Application number: 2024/91760	
What is the application for?:	Erection of 19 dwellinghouses with associated car parking, landscaping and bound
Address of the site or building:	Land adj Healey Junior Infants and Nursery School, Healey Lane, Healey, Batley, WF17 8BN
Postcode:	LS28 6RW

Type of comment: An objection	
Do you wish your comments to be published on the website anonymously?	Yes

I am writing to formally object to the proposed development application 2024/91760 for 19 properties

Block G Architectural Drawings			
Name	(557)2405-GWP-00-00-D-A-(PA)-0021		
Scale	1:100@A1	Revision	P06
Drawn/Checked	JB / DT	First Issue	10.05.24
Drawing Status	S0 - Information

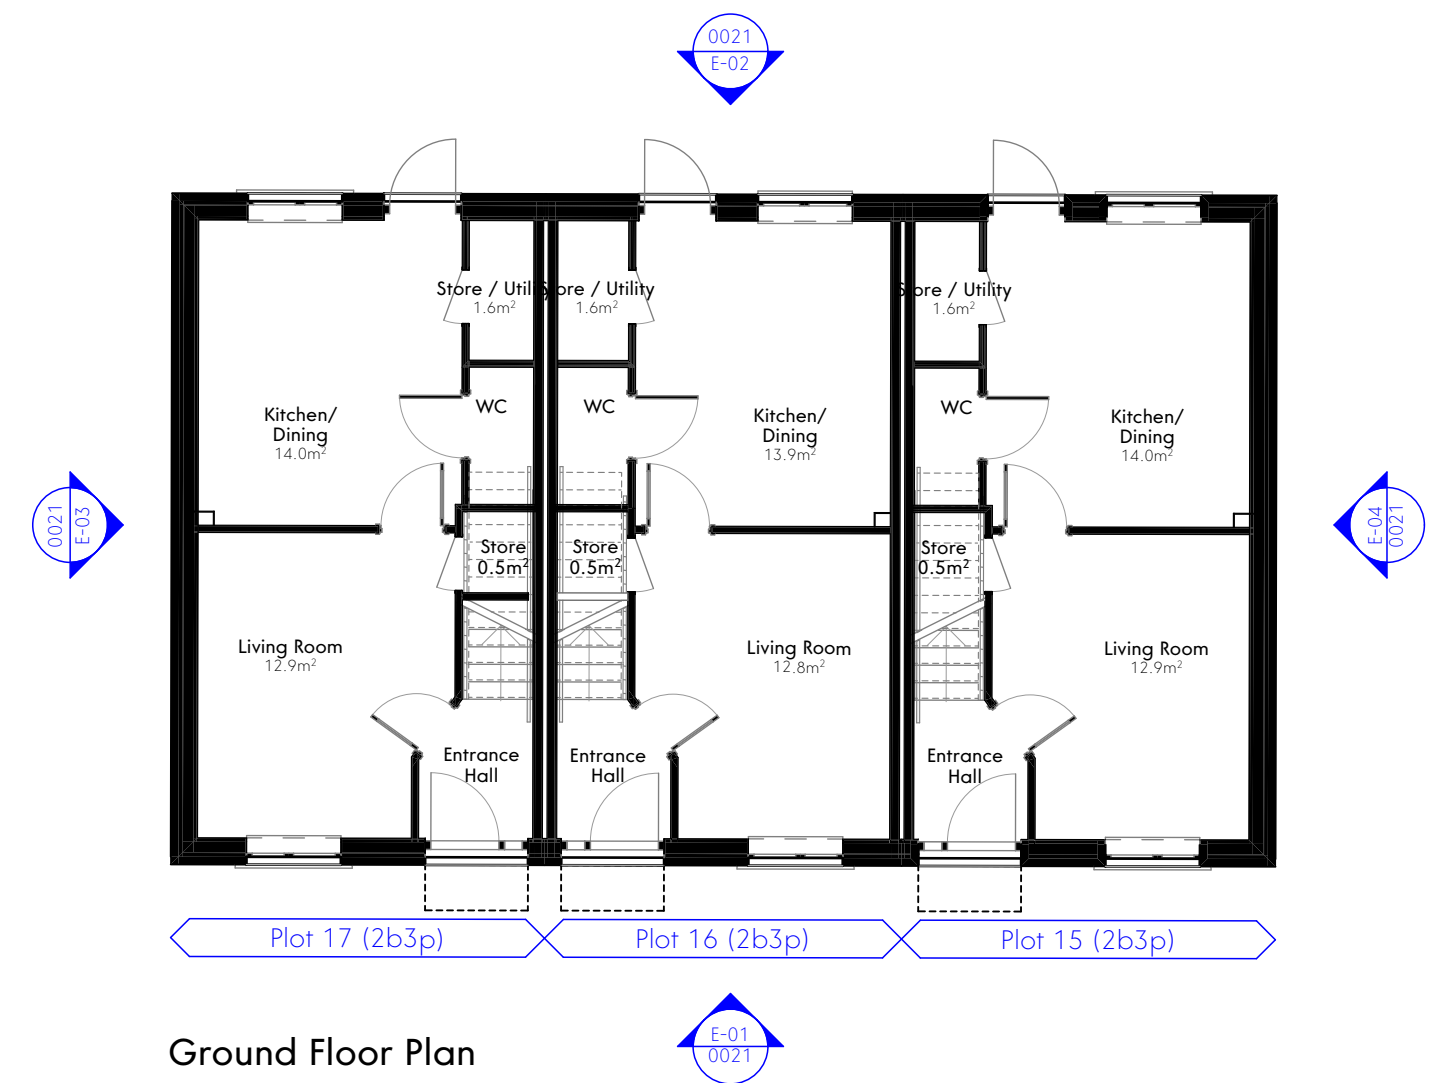
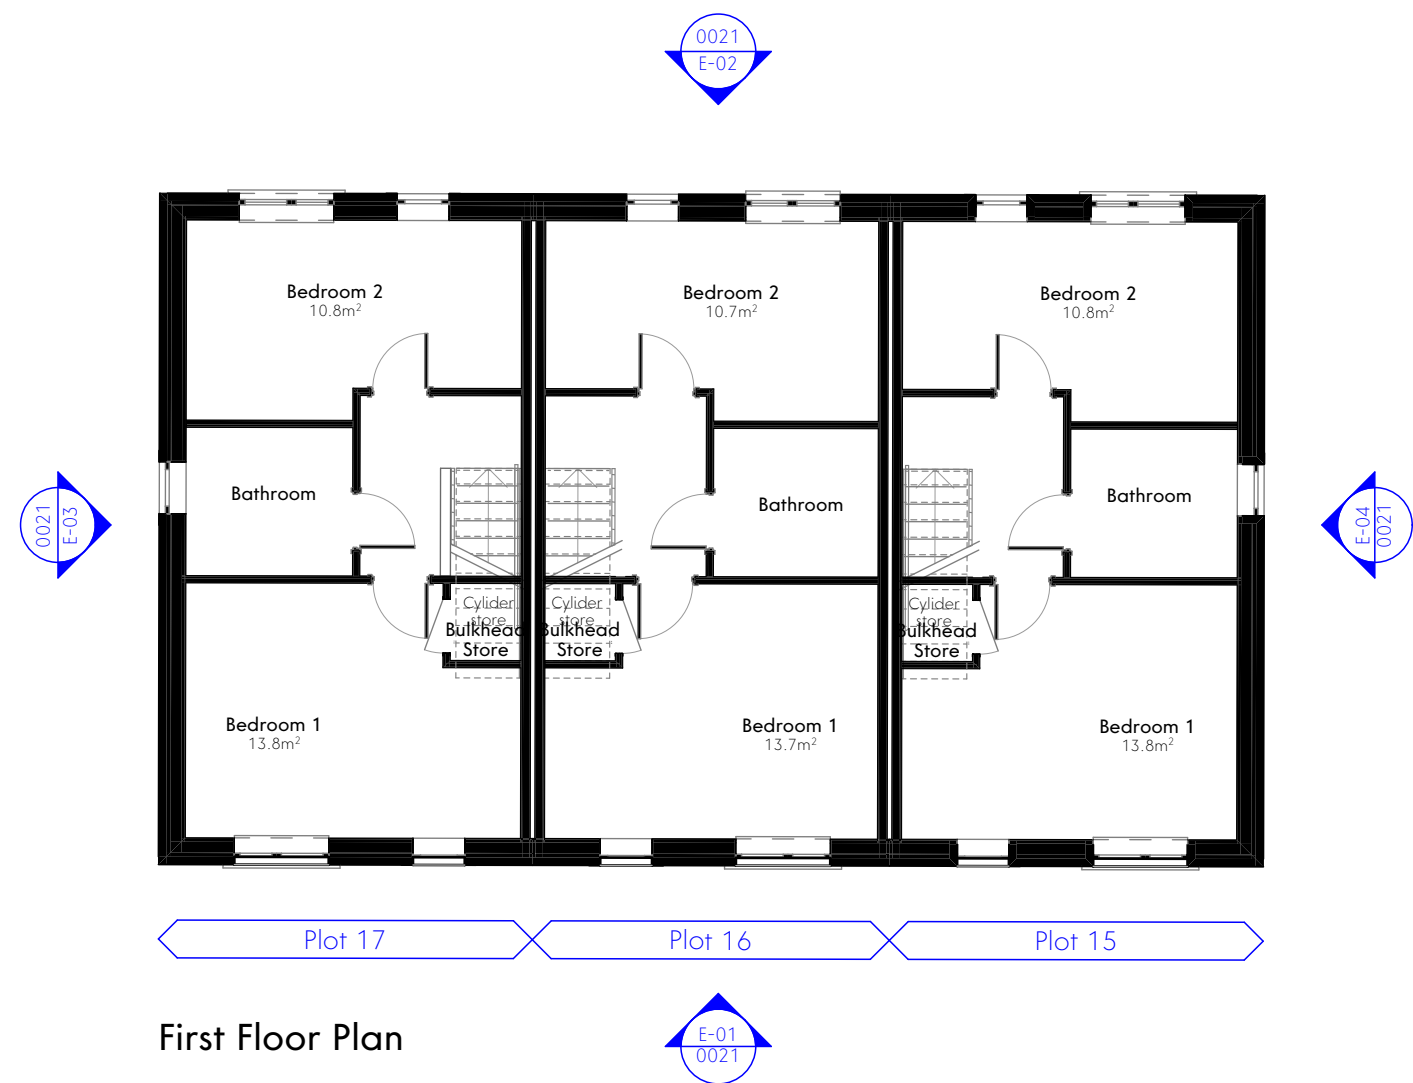
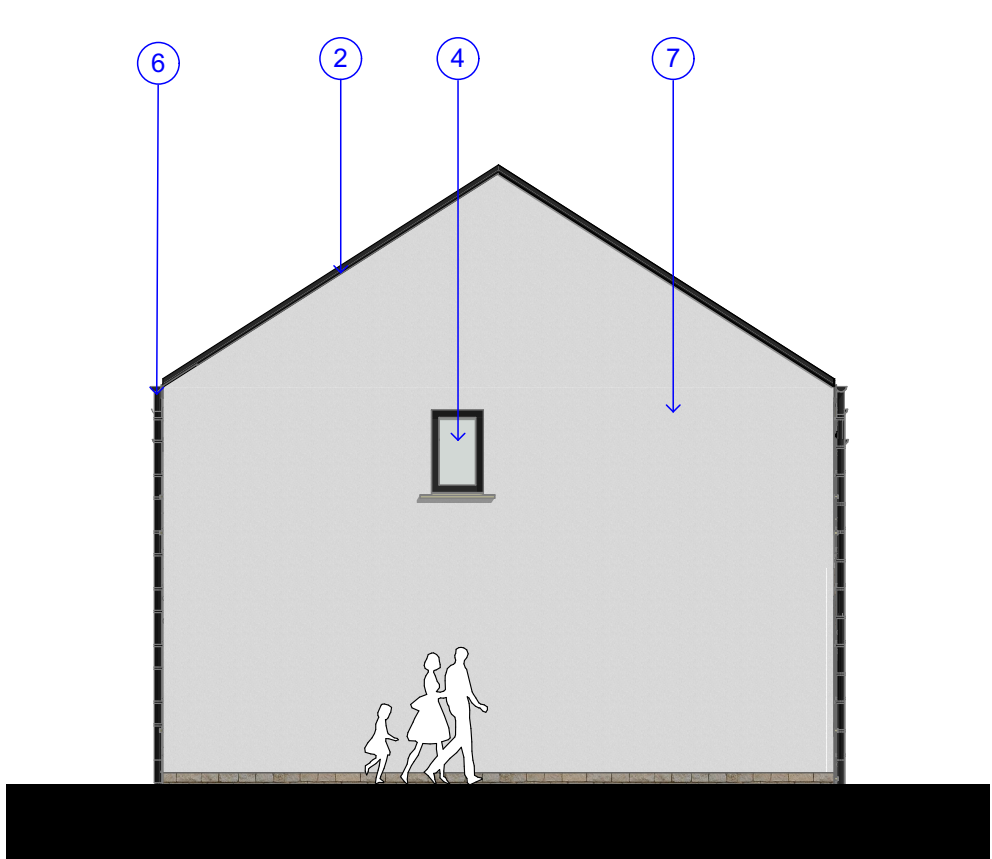
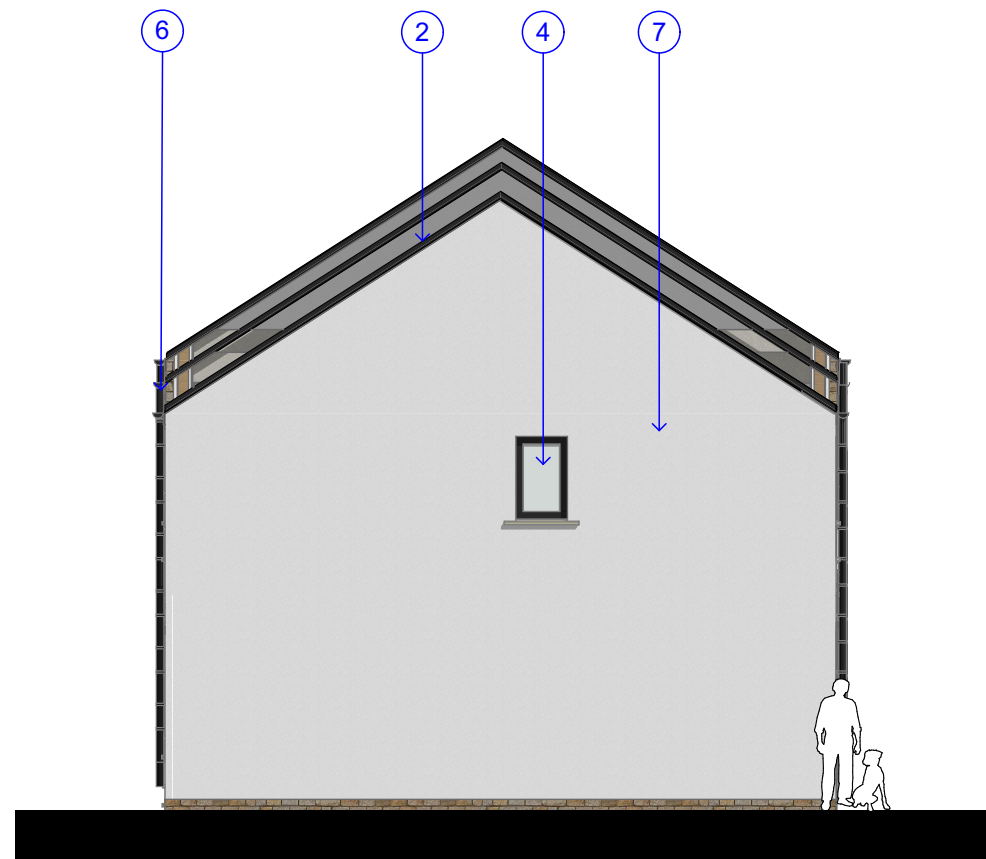
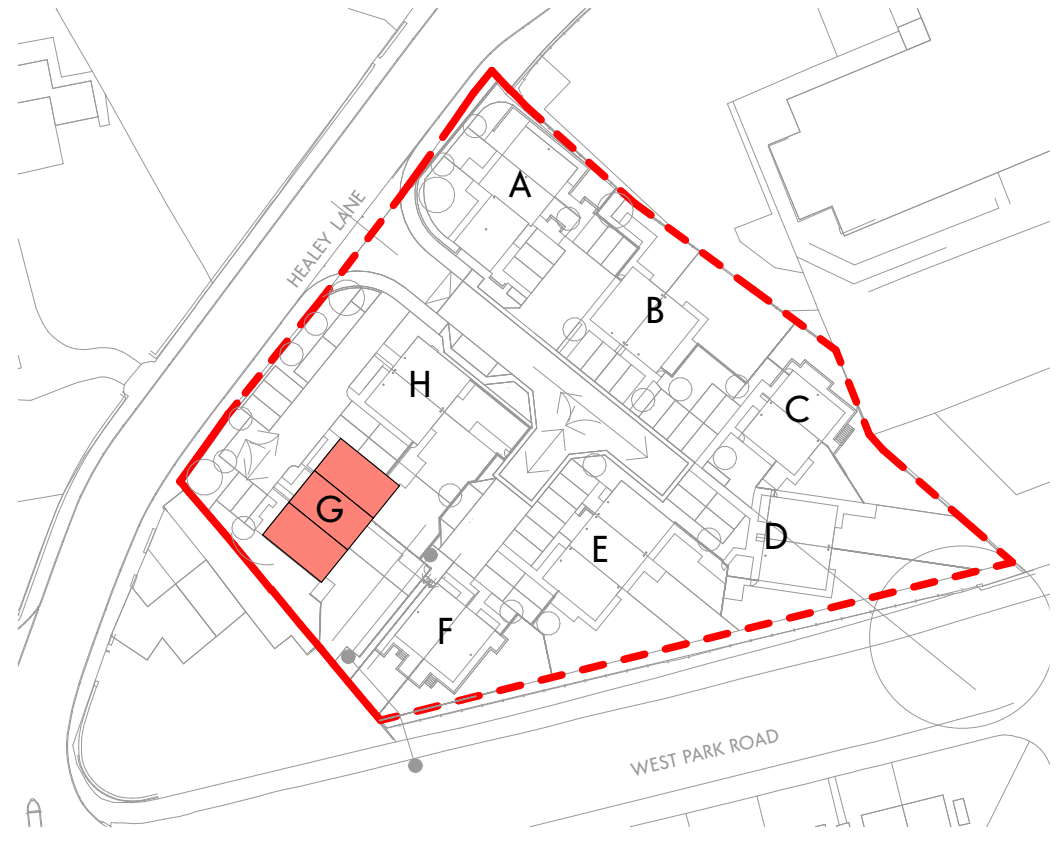
The proximity of House 15 in Block G, situated a mere 3.5 to 4.5 meters from

coupled with its extensive height, will significantly overshadow

This development would substantially obscure the daylight
